Our reference: 8059597
Contact: Gavin Cherry
Telephone: (02) 4732 8125

Response to modification application for the Oakdale South Industrial Estate at Kemps Creek (SSD 6917 MOD 7 & SSD 7719 MOD 1)

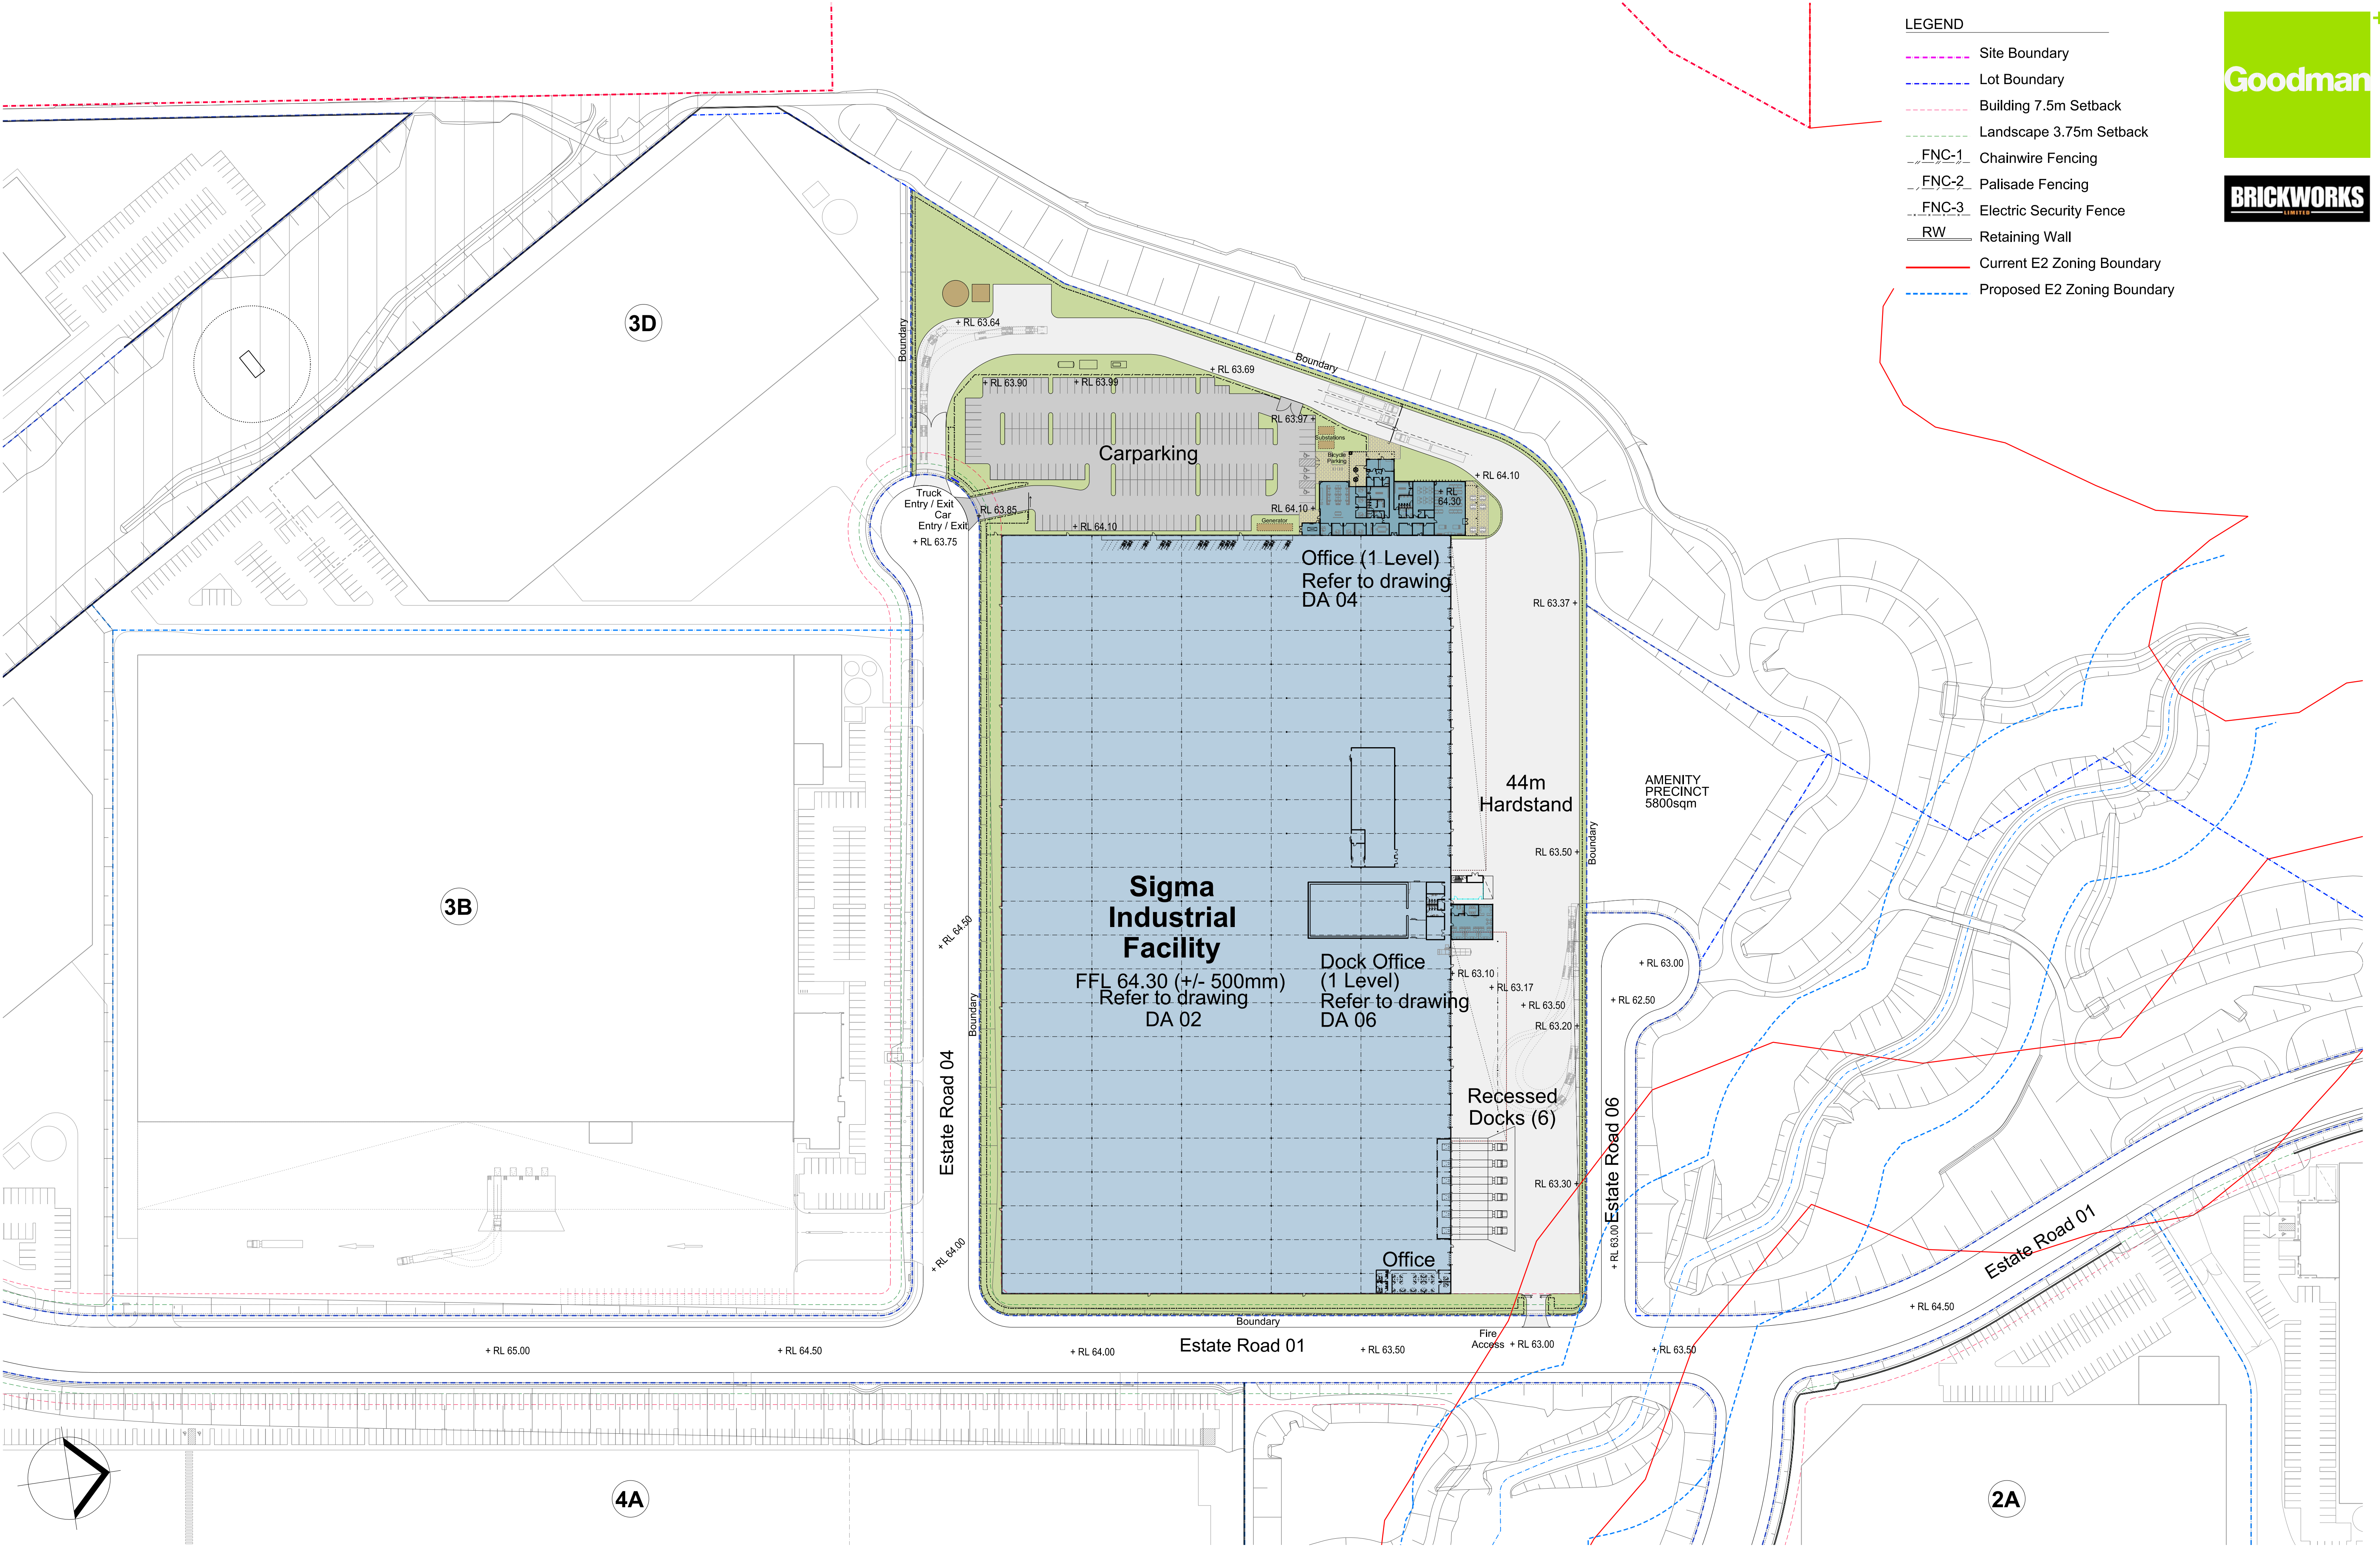
While the rezoning may be appropriate given the approved road configurations, the proposed extent of additional hard stand area now proposed is not considered to be appropriate at this intersection and an improved landscape setback between the property boundary and car parking areas should be required.

The proposed plans provide for a 2.5m setback to Road 06 which is inadequate given the location of this site. The corner of the site (south east) requires an embellished landscape setback to frame the intersection of Estate Road 6 and Estate Road 1 which is planned to be embellished to the east and south. The extension of the hard stand out to the intersection area does not suitably respond to the contextual planned landscape character of this intersection, and an increased setback should be provide.

It is also recommended that the access driveway to Estate Road 01 be relocated to Estate Road 6 to provide an unbroken landscape connection along Estate Road 01 for the full width of the lot. This would suitably address the landscape character of this road as well as sites relationship to the E2 zoned land further east. This option may still enable the proposed 2.5m landscape setback to Road 06 further north of the intersection, away from the intersection which is the primary view corridor within the development.
